Recommendation Report for Planning Permission for Works or Extension to a Dwelling

REF NO: FG/74/26/HH

LOCATION: 160 Littlehampton Road
Ferring
BN12 6PH

PROPOSAL: Proposed alterations to front elevation to include extended porch and roof gable over existing bay. Two storey side/front extension and proposed rear/side single storey extension.

FRONT NORTH ELEVATION
PROPOSED ELEVATIONS
Scale 1:100

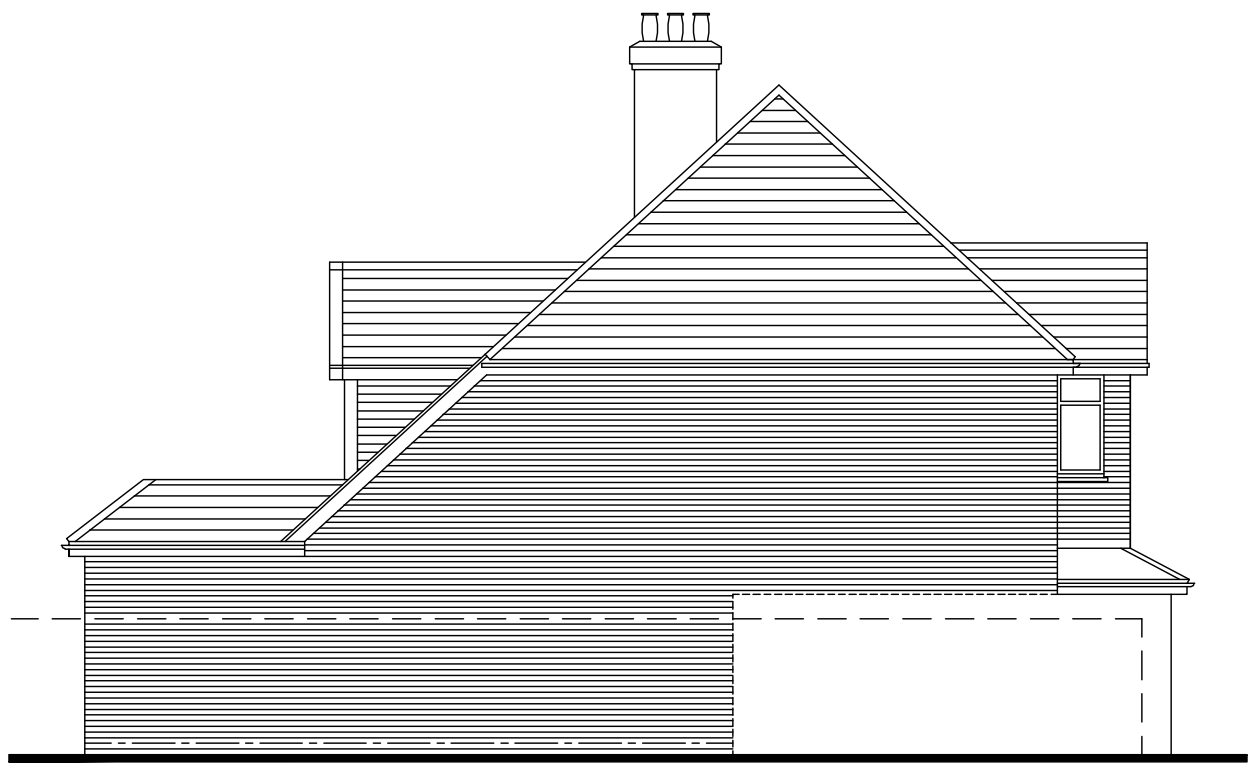
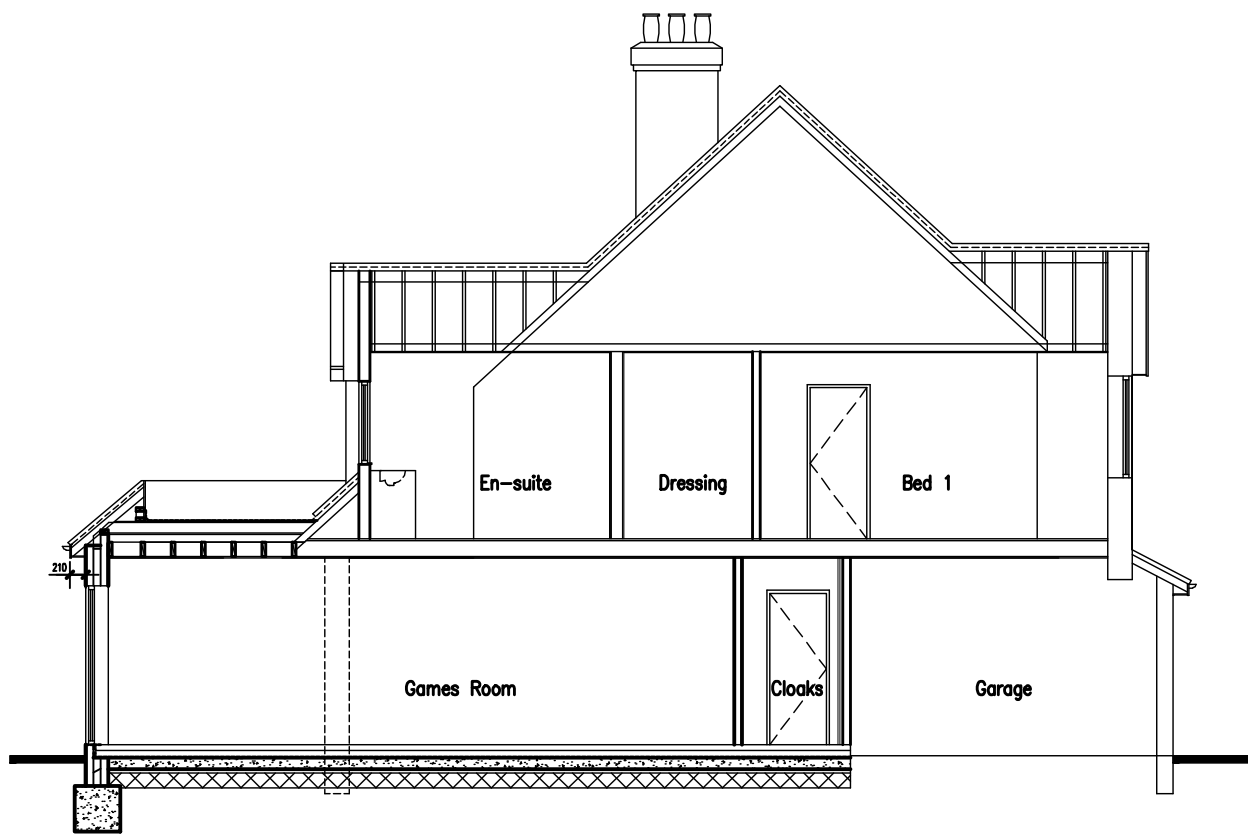
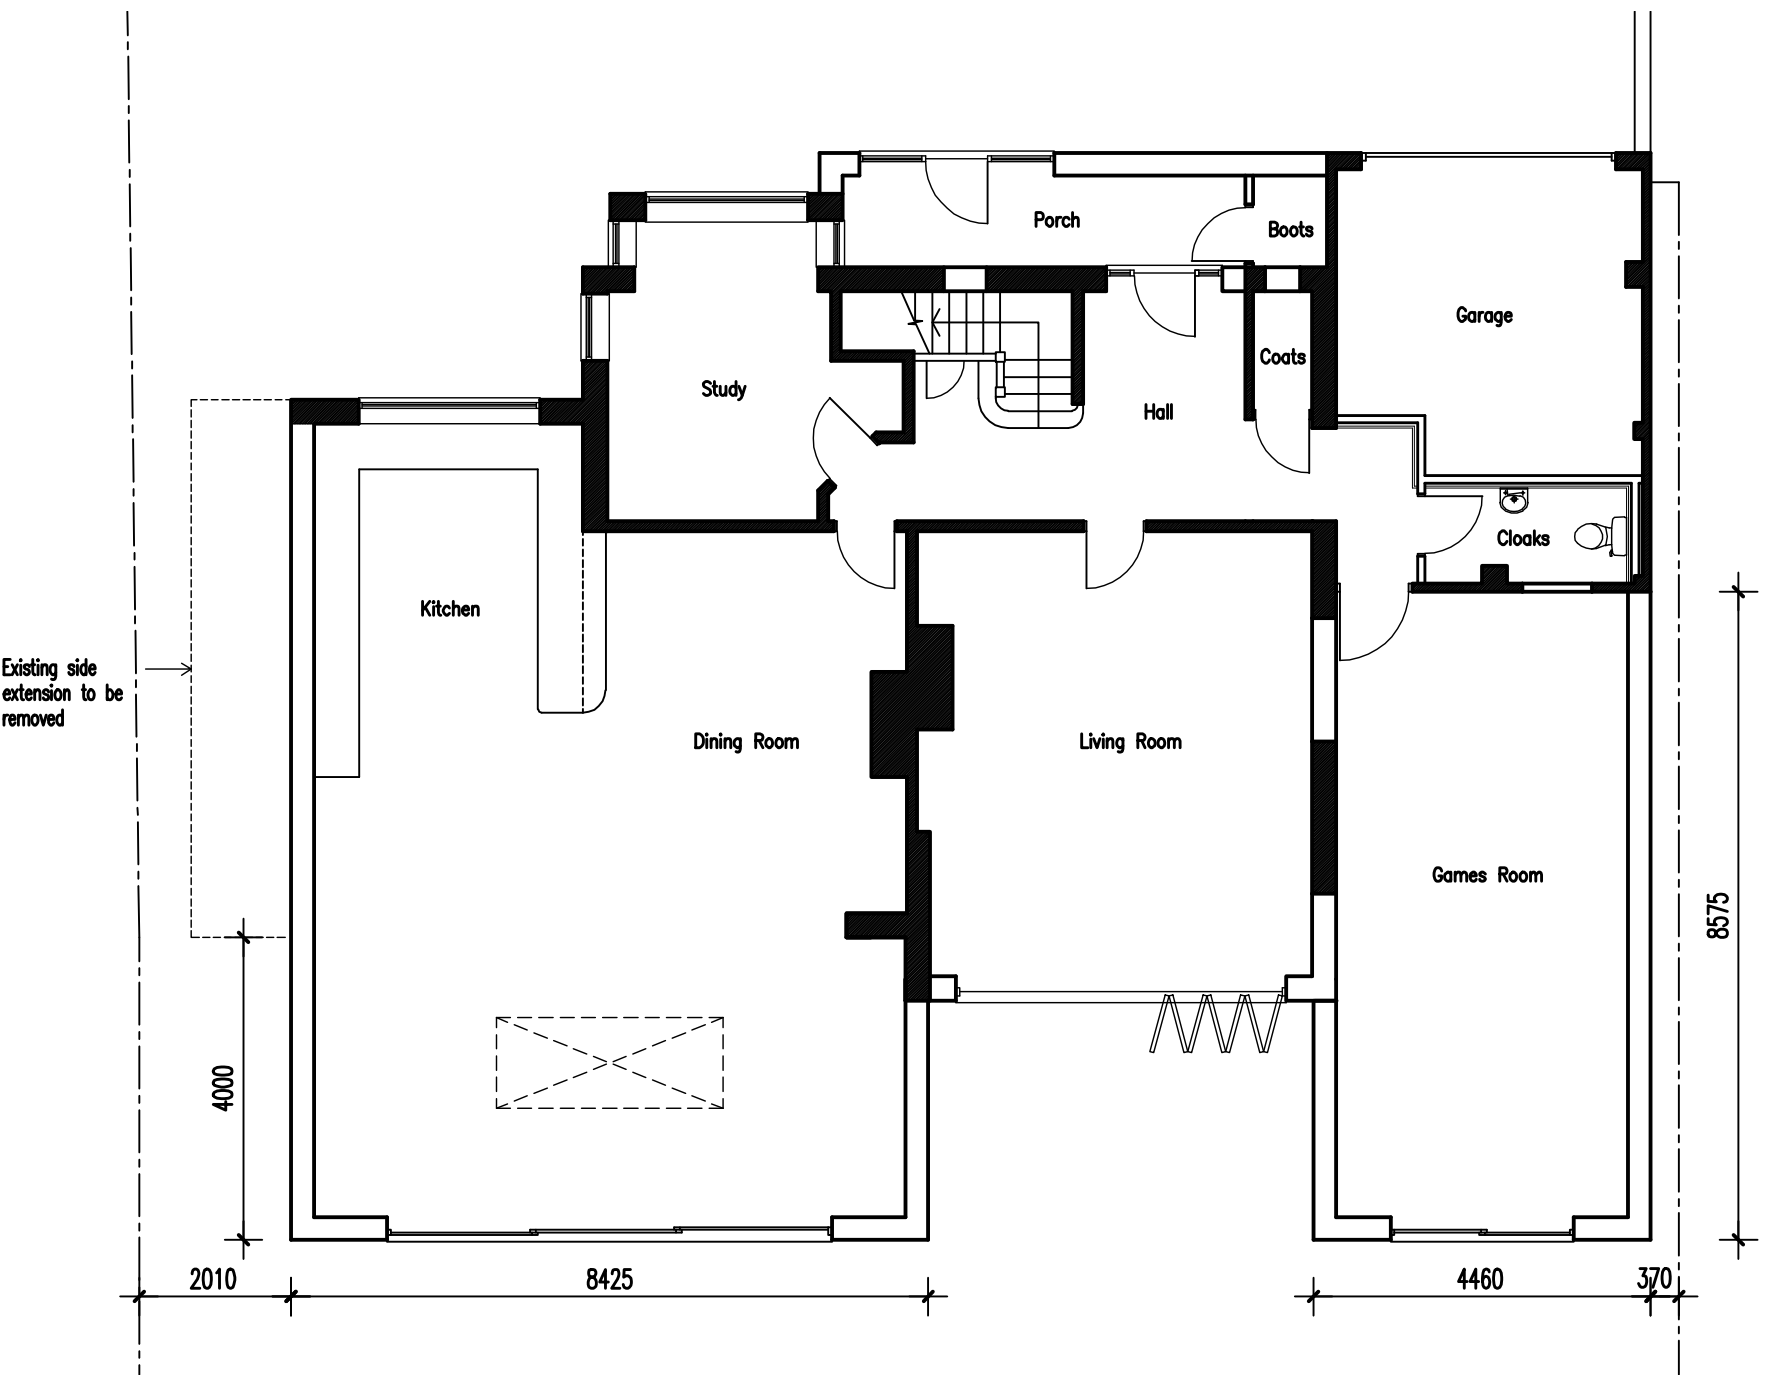
The proposed front porch would retain the existing depth of approximately 1.5m with an increased width, resulting in an overall width of approximately 6.7m. The extension would block the existing stairwell window and reposition the entrance door. The porch would retain the existing hipped roof design with a flat-topped central section and a maximum height of approximately 3.5m. External materials would match those of the existing dwelling, in accordance with the guidance of the Arun Design Guide (ADG).

The proposed two-storey side/front extension would be constructed above the existing garage and would extend further along the eastern flank of the dwelling towards the rear. The ground floor element would measure approximately 4.4m in width and 8.5m in depth, with the first-floor element extending to an overall depth of approximately 10.5m. The extension would continue the existing hipped roof form to the front elevation, with a crown roof incorporated over the rear ground floor projection. The ridge height would match that of the existing dwelling. New bay windows incorporating gabled roofs would be provided on both the front and rear elevations, reflecting the appearance of existing windows of the host dwelling. Additional alterations include the installation of a rooflight within the rear roof slope and large glazed doors serving the rear amenity space. External materials would comprise of facing brickwork, concrete roof tiles to match the existing dwelling in accordance with the Arun Design Guide (ADG).

The extension would be visible within the street scene. Whilst it would not be set back from the principal elevation and would not appear subordinate to the host dwelling, due to its two-storey scale and matching ridge height, it would follow the established architectural style of the property and create a balanced and cohesive appearance. In this respect, the proposal would not fully accord with the ADG guidance, which advises that side extensions should be subordinate in appearance and have a ridge height at least 0.5m lower than the host dwelling.

Notwithstanding this, the dwelling occupies a generous plot and is set approximately 30m back from the front boundary. The surrounding area is characterised by a varied pattern of development, including dwellings of differing scale, form and architectural style. Although the proposed extensions and roof

alterations would result in a noticeable increase in the overall bulk and massing of the dwelling, the development would remain proportionate to the size of the plot and would not appear incongruous within the wider street scene. Furthermore, the proposed development would retain a coherent design approach and would preserve the overall character of the host dwelling. Accordingly, the proposal would be acceptable in visual terms and would be in accordance with Arun Local Plan (ALP) policies D DM1 and D DM4.

The proposed single-storey rear extension would be constructed partly on the footprint of the existing side extension, which would be removed, creating a wraparound form of development with the side extension. The newly constructed element would measure approximately 4m in depth, resulting in an overall depth of approximately 11.1m, and would have a width of approximately 8.4m. The extension would incorporate a crown roof design with a maximum height of approximately 3.6m and an eaves height of approximately 2.8m. Fenestration would comprise large glazed sliding doors opening onto the rear garden together with a roof lantern within the flat roof section.

The rear extension would incorporate materials and detailing that match the existing dwelling and the remainder of the proposed development, ensuring a cohesive appearance. Whilst the extension would exceed the ADG guideline depth of 3.3m for single-storey rear extensions, it would remain proportionate to the scale of the property. Due to its location to the rear of the dwelling, it would not be prominent within the public realm and would not be visible from Littlehampton Road. As such, the extension would not result in harm to the character or appearance of the dwelling or the surrounding area.

The proposed two-storey side extension would be set in approximately 0.3m from the eastern side boundary. Whilst the extension would intersect a 45-degree splay line taken from the centre of the closest neighbouring window and, by reason of its increased bulk, massing and proximity to the shared boundary, would result in some additional overshadowing to the neighbouring property to the east, this impact must be considered in the context of the existing relationship between the properties. In particular, the proposed ridge and roof form would align with the existing recessed rear elevation of the neighbouring dwelling, and as a result, the majority of the additional built form would not project significantly beyond the neighbouring property's rear building line. As such, whilst some increase in overshadowing would occur, the resulting impact would not result in demonstrable harm as to justify the refusal of planning permission.

PROPOSED GROUND FLOOR PLAN
Scale 1:100

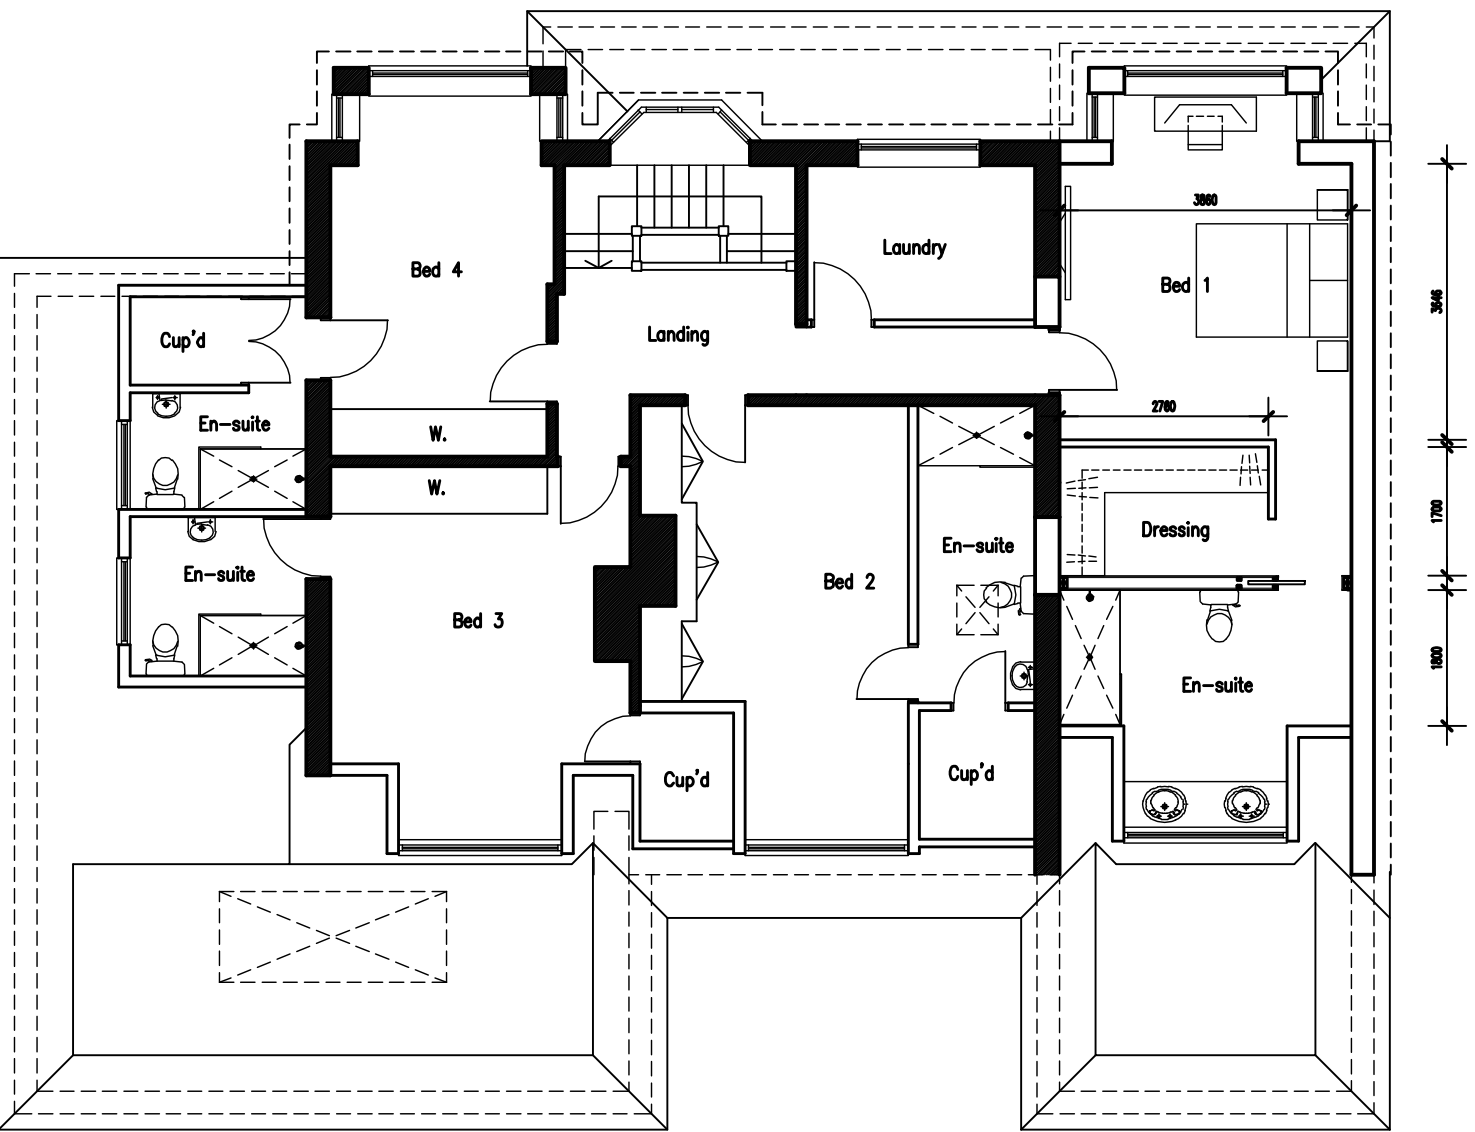
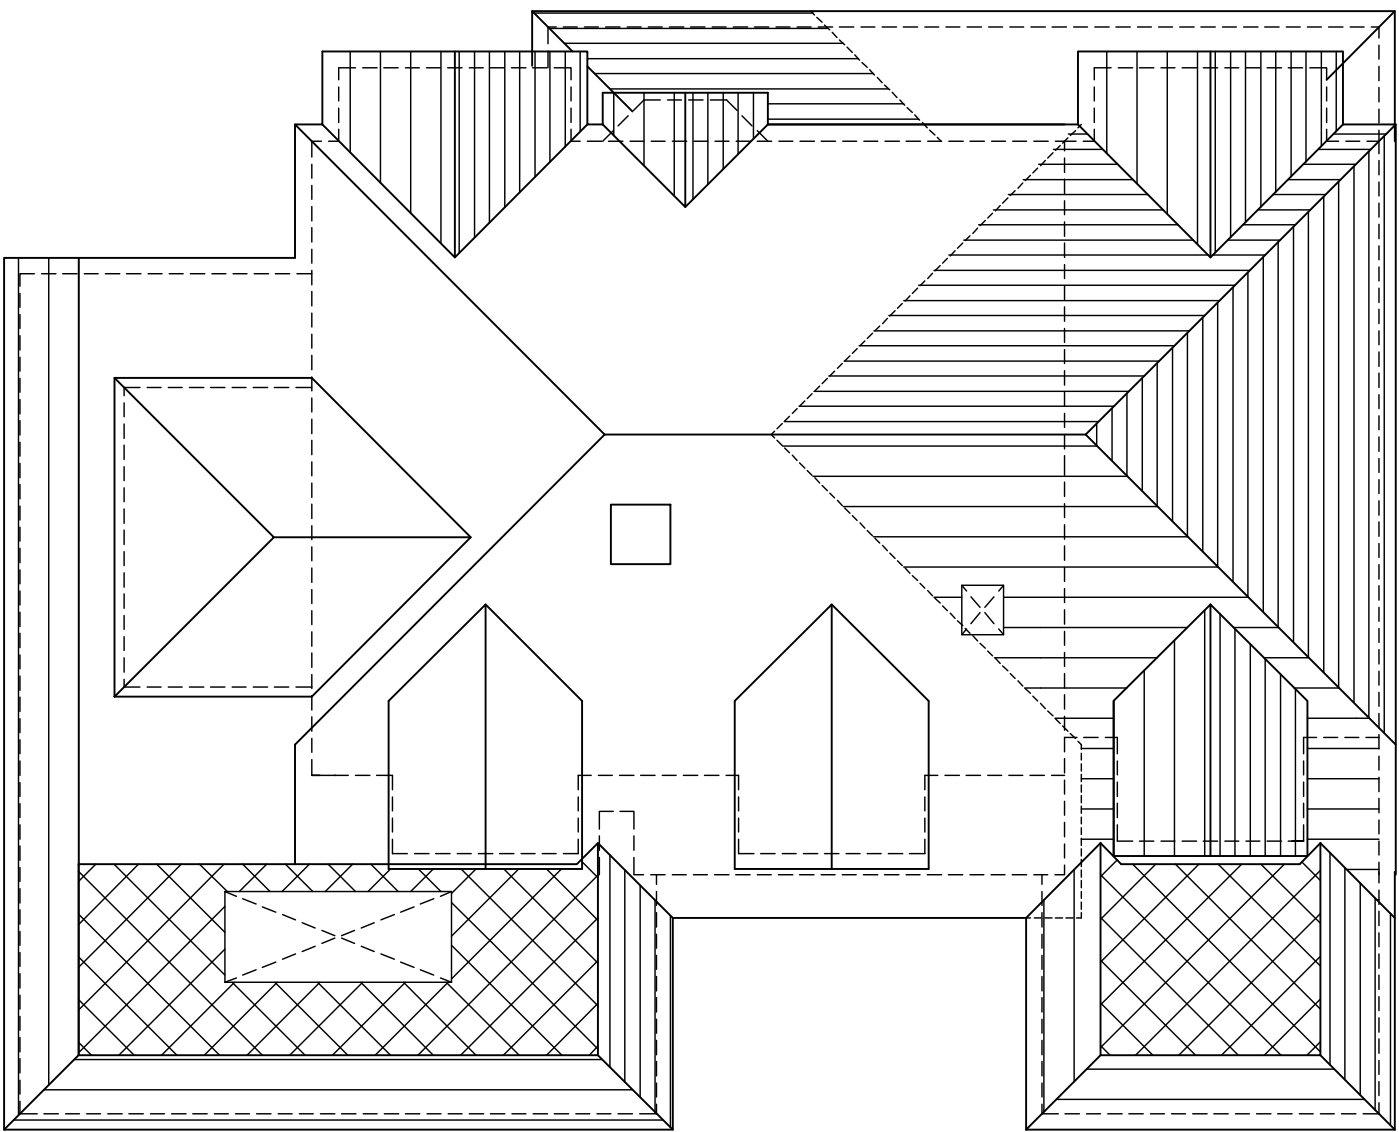
The proposed single-storey rear extension would be set approximately 2m from the neighbouring side boundary. Due to its single-storey form, modest height and adequate separation from adjacent boundaries, the extension would not result in overshadowing or overbearing impacts to neighbouring occupiers.

development would remove existing openings within the eastern elevation, thereby reducing opportunities for overlooking towards the neighbouring property to the east. Similarly, existing ground-floor openings within the western elevation would be removed. The proposed rear-facing openings would overlook the site's extensive rear garden and would provide a level of outlook broadly comparable to the existing arrangement. As such, the proposal would not result in any loss of privacy to neighbouring occupiers.
